October 24, 2005

RE: Harnett County Land Use Application 05-5-13239

Joe West, R.S.
Environmental Health Specialist
Harnett County Health Department

The Jarrod

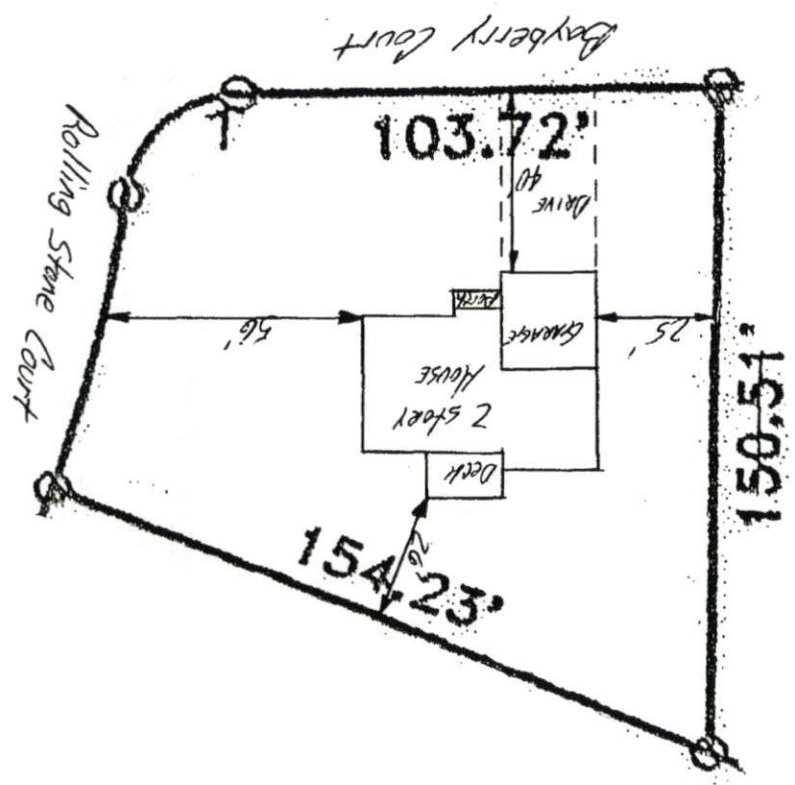
- 1. Property lines/corners not marked or labeled
- 2. House corners not marked or labeled
- 3. Directions not clear to property
- 4. Property needs brush or vegetation remove
- 5. Backhoe pits required
- 6. Other **Maximum limit of bedrooms is 3 on this particular lot. Please submit your changes to Central Permitting.**
